Colorado Springs, CO
Planning and Development

Final Report - Corrections Required
Application No. COPN-23-0014

Description : Peak Innovation Park intends to expand Use Area 2 within Lot 7, east to the Colorado Springs Airport property boundary and north up to Drennan Road. This expansion allows for future development within the Peak Innovation Master Development that will be consistent with the existing allowed uses.

Record Type : Concept Plan

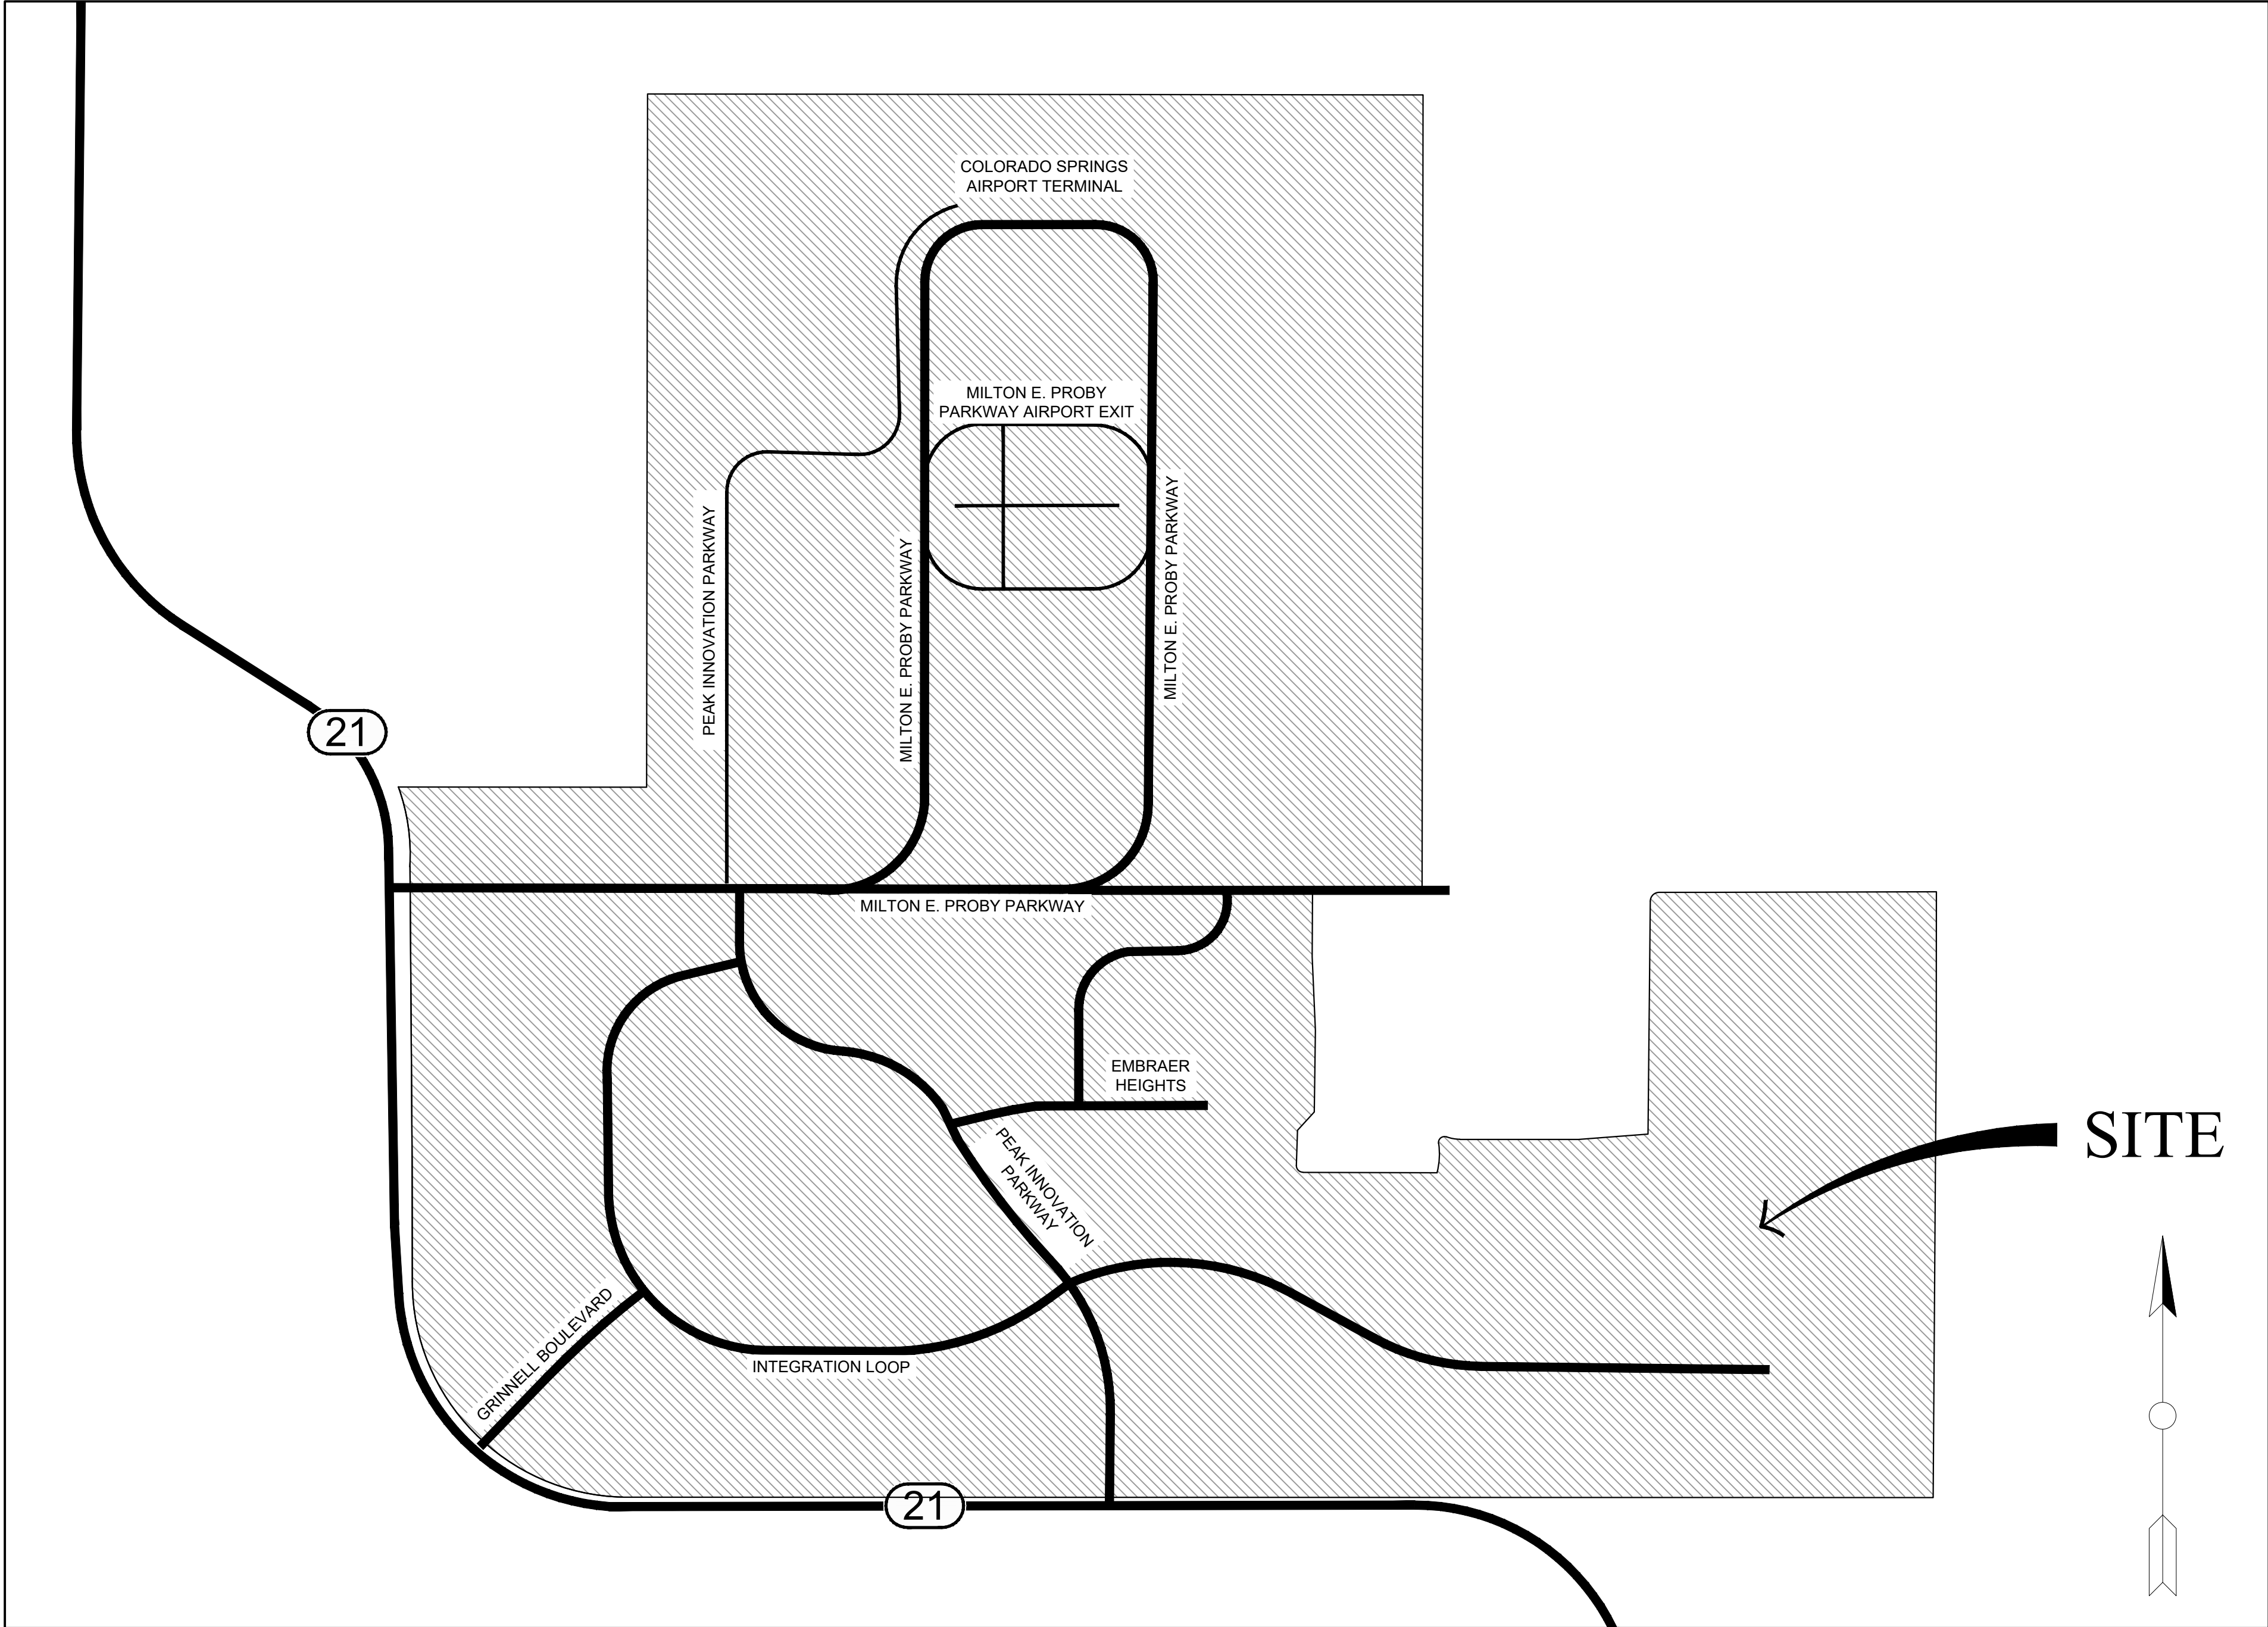
Comment ID	Page Reference	Author : Department	Review Comments
10	1	Hao Vo : City Engineering - SWENT	A Drainage memo is required to be submitted to support the plat concept plan. Please provide the STM review number once submitted.
11	3	Hao Vo : City Engineering - SWENT	This Site is apart of mutiple FIRMs, ensure all are listed.
7	1	Patrick Morris : City Engineering Dev Review	EDRD has no comments on this concept plan amendment.
5	2	Mike Gackle : Col Springs Utilities	Submit an HGL request form.
6	2	Mike Gackle : Col Springs Utilities	Submit a wastewater Master facility Form.
8	1	Mikaela Colgrove : COS Airport	Airport has no comments.
